**Briargate Bridge at Sand Creek
Design Report
Sand Creek Drainageway**

El Paso County, Colorado

April 29, 2022

CDR-21-013

FIGURE 1
VICINITY MAP
BRAIRGATE BRIDGE

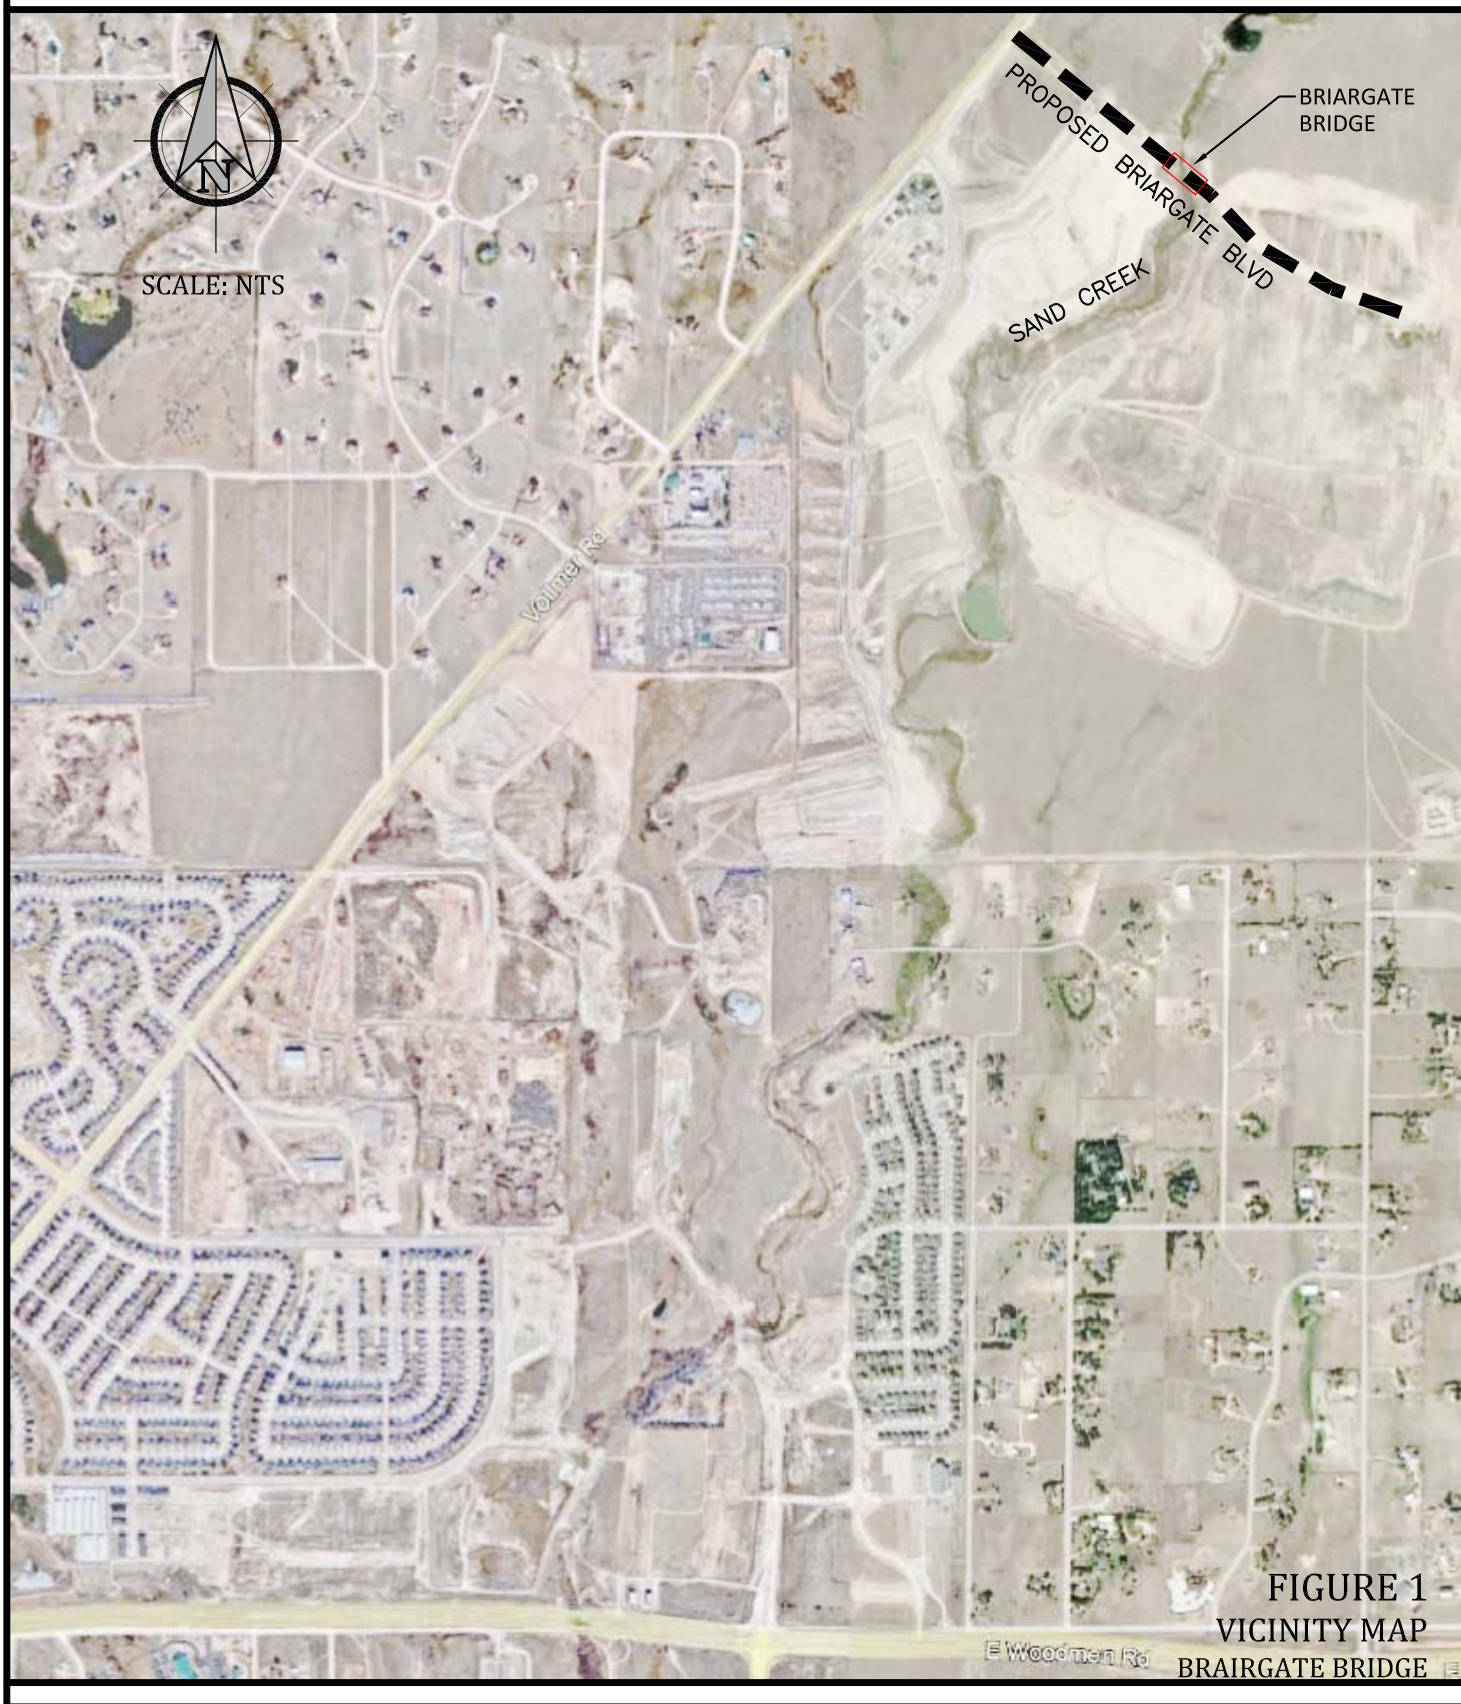
← Wrong project
